Re: **I-Joist Issue**

Location: Lot 29 Mason Ridge (93 Fair Child Rd. (Spring Lake, NC))
JDS Project No.: RDU2502640
Date of Inspection: 03/14/25

DR Horton
29 Mason Ridge
Hayden K
FLOOR JOIST LAYOUT

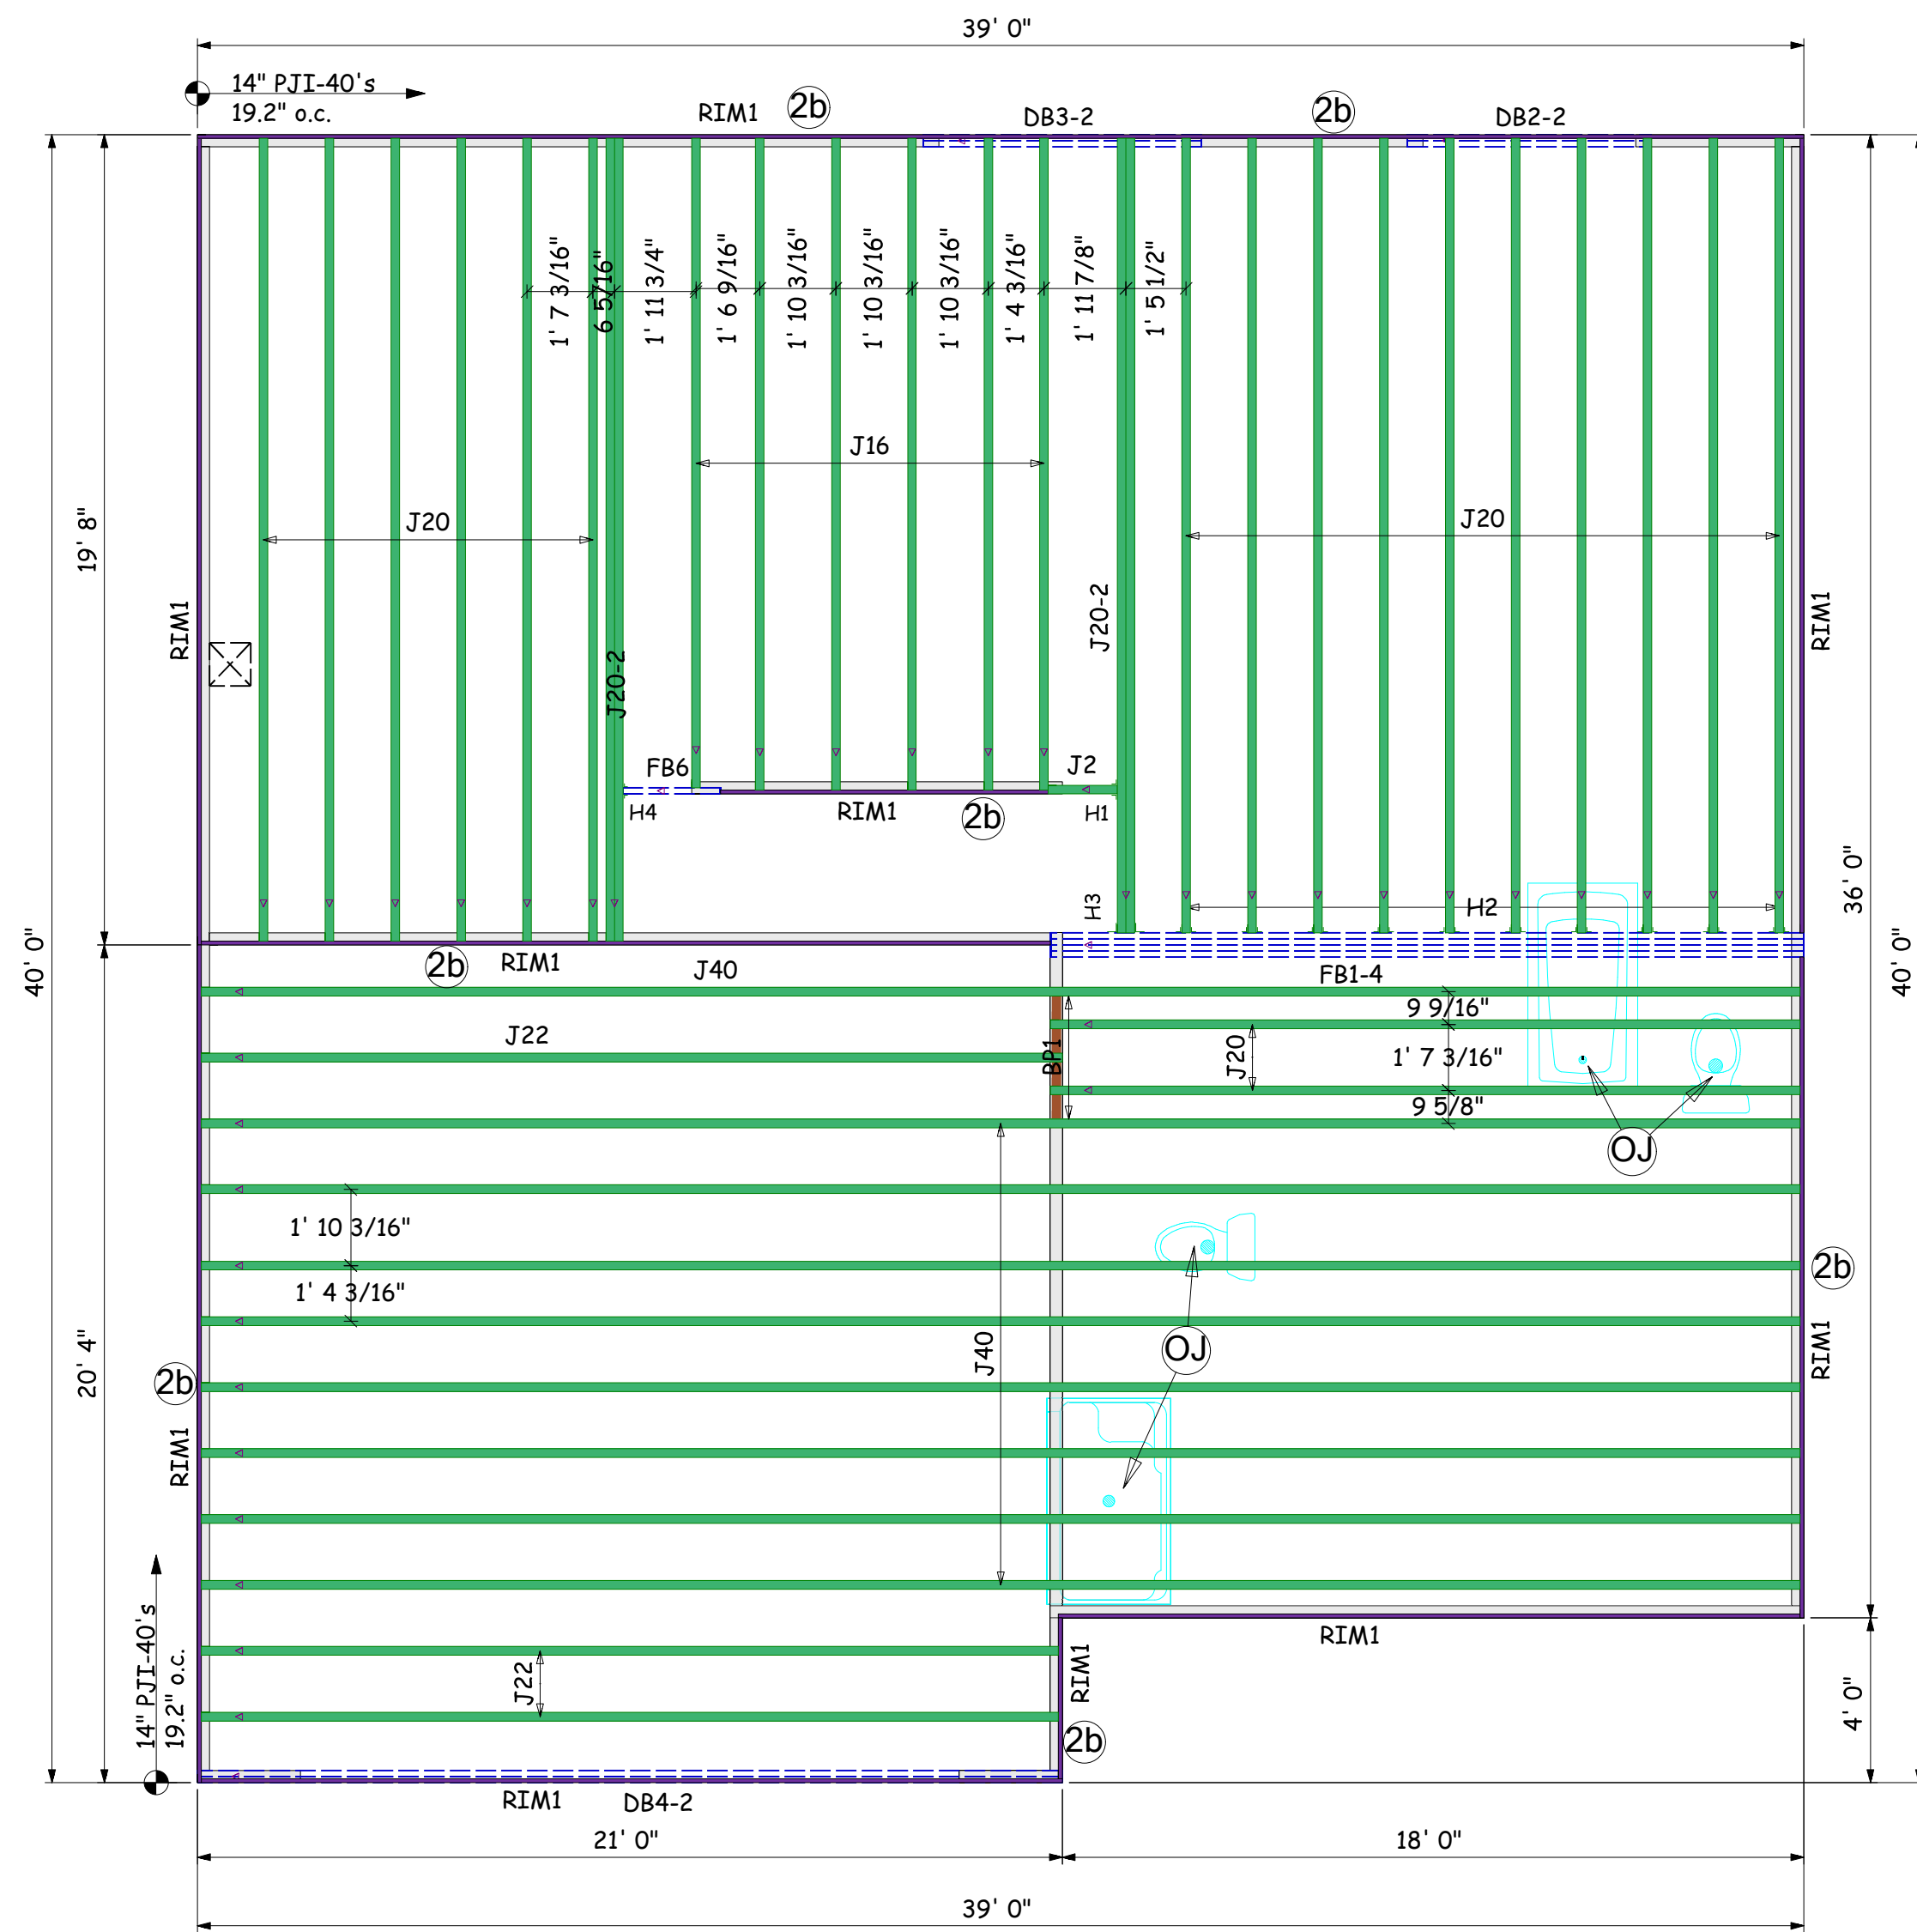
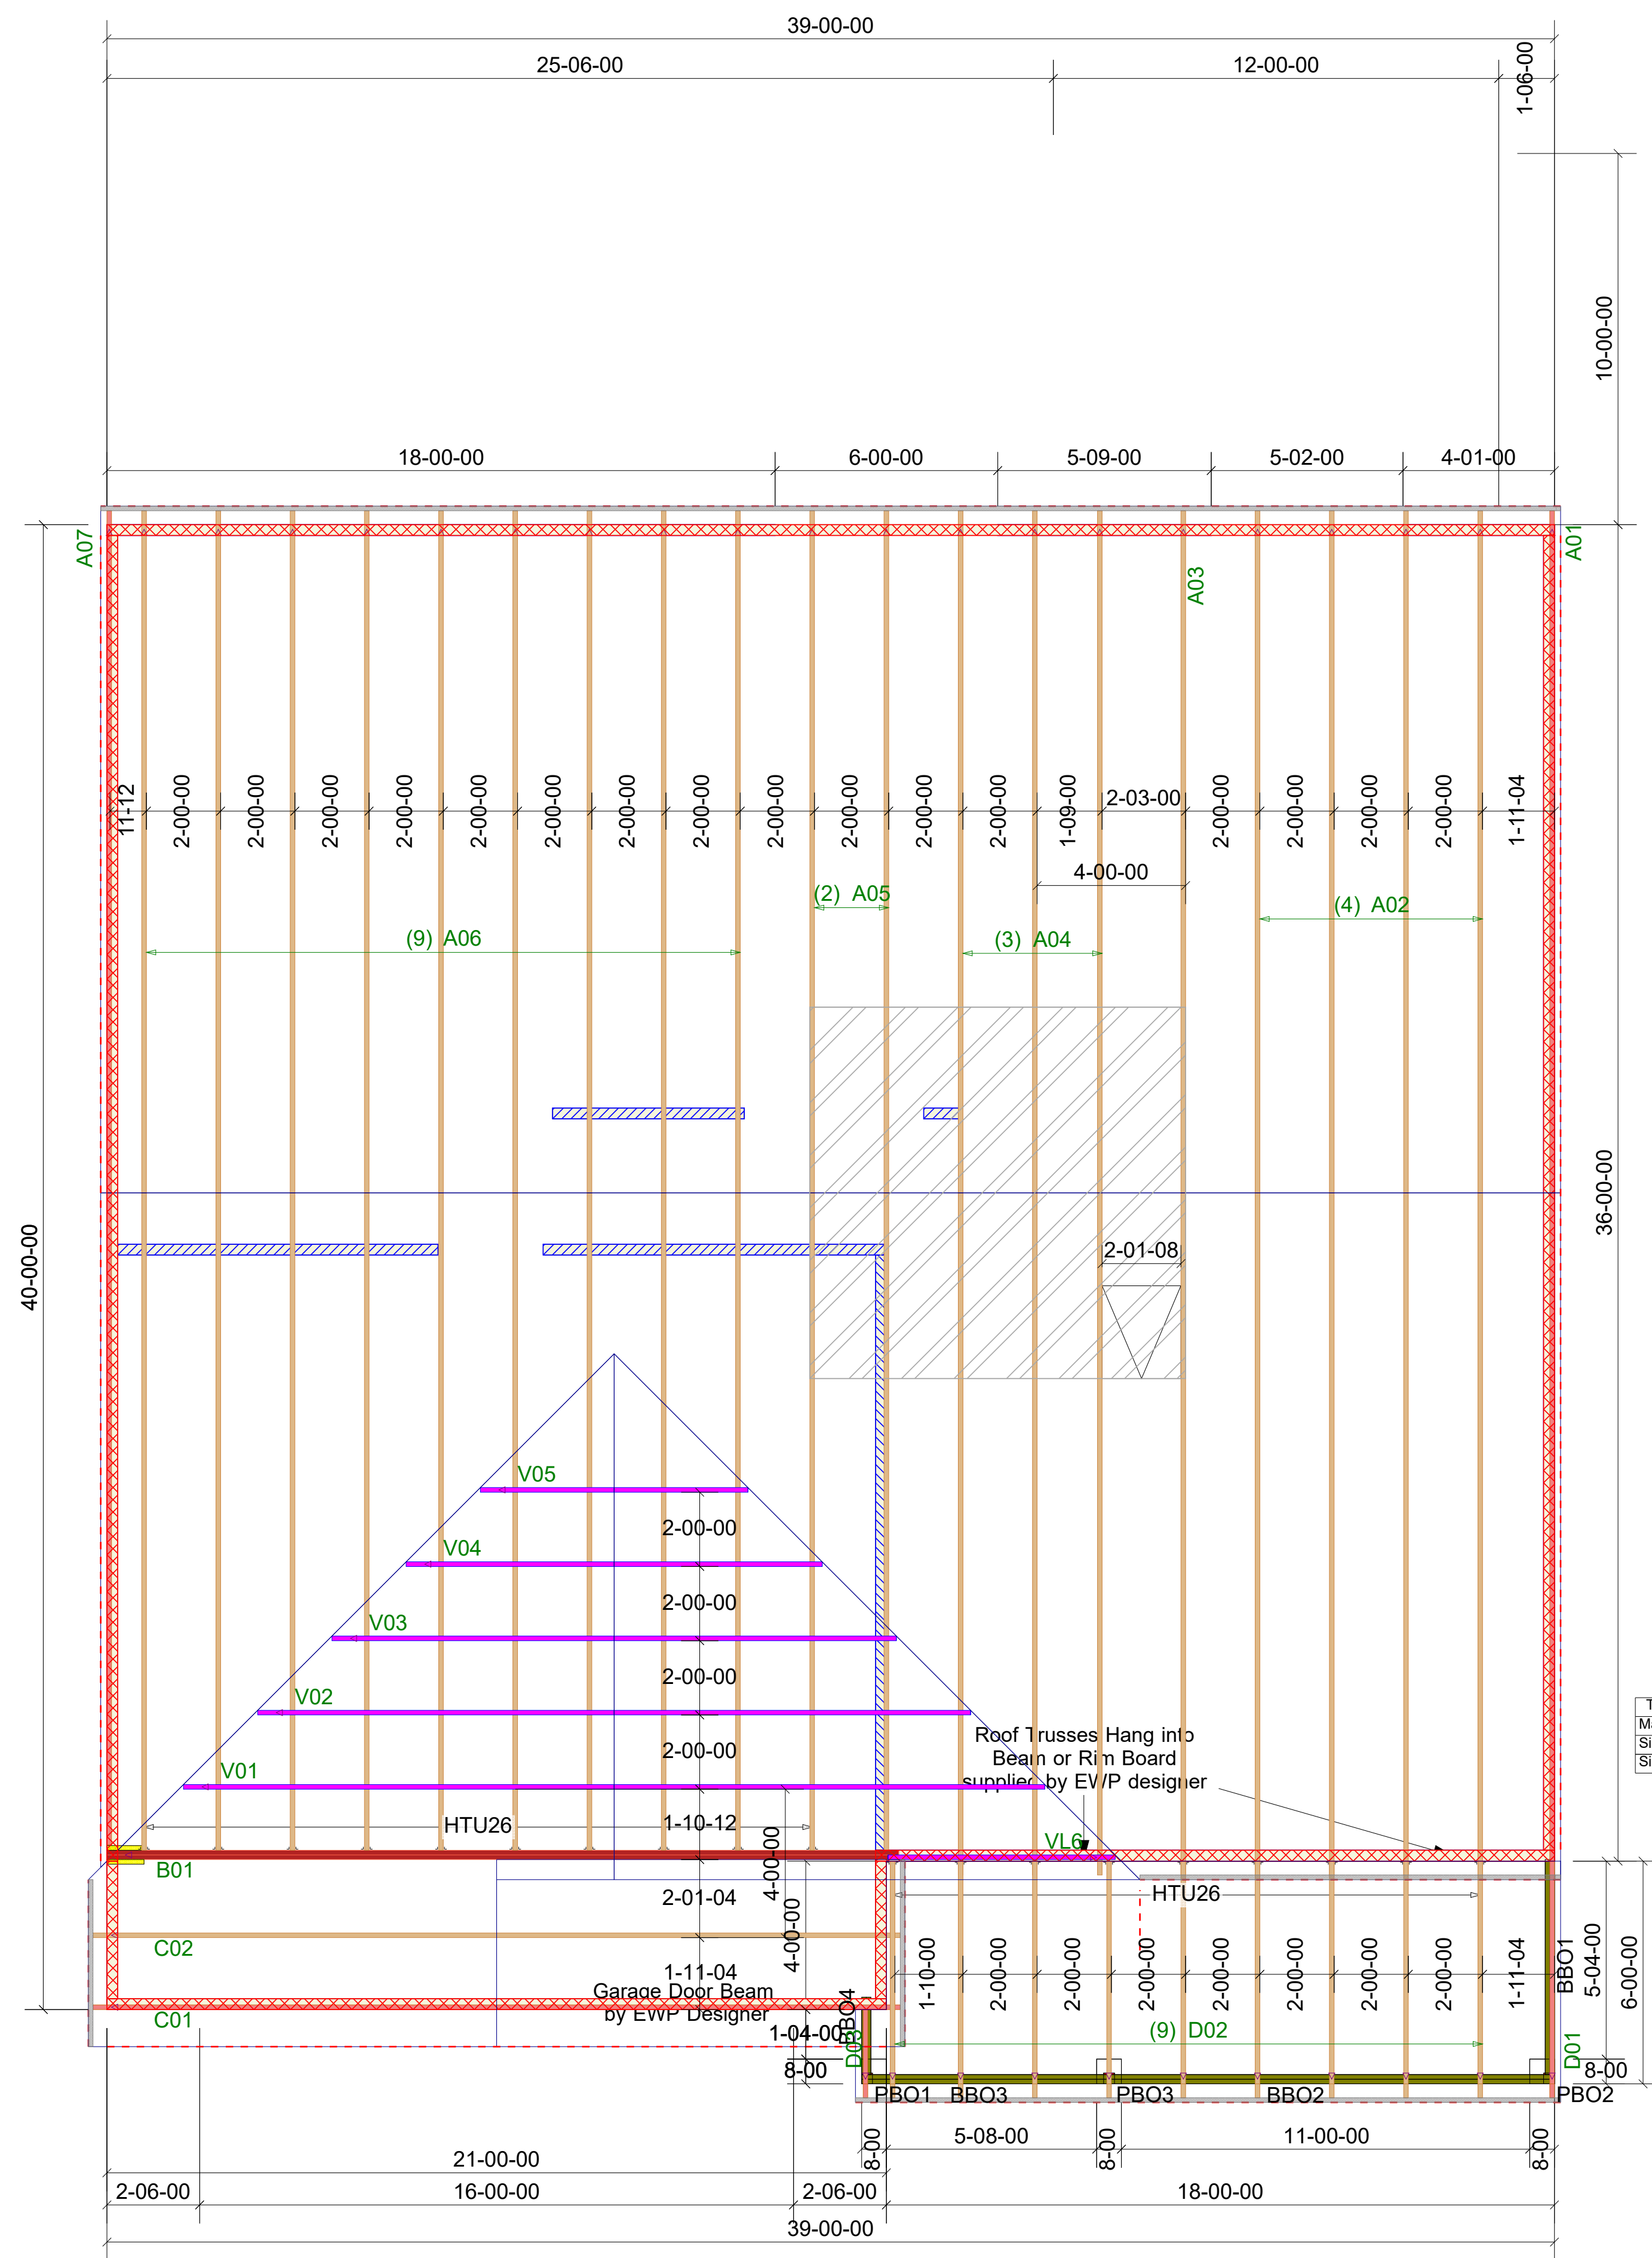
The inspector is questioning the location of the double I-joist at the rear garage door. The structural plans show the double I-joist that bears at the rear garage door showing close to the left stud column of the door, where the double I-joist is bearing near the center of the rear garage door. The I-joist layout shows that the double I-joist at the end of the top of the stairs.

Based on our on-site observations and review, the double I-joist is installed per plans; no further action is required.
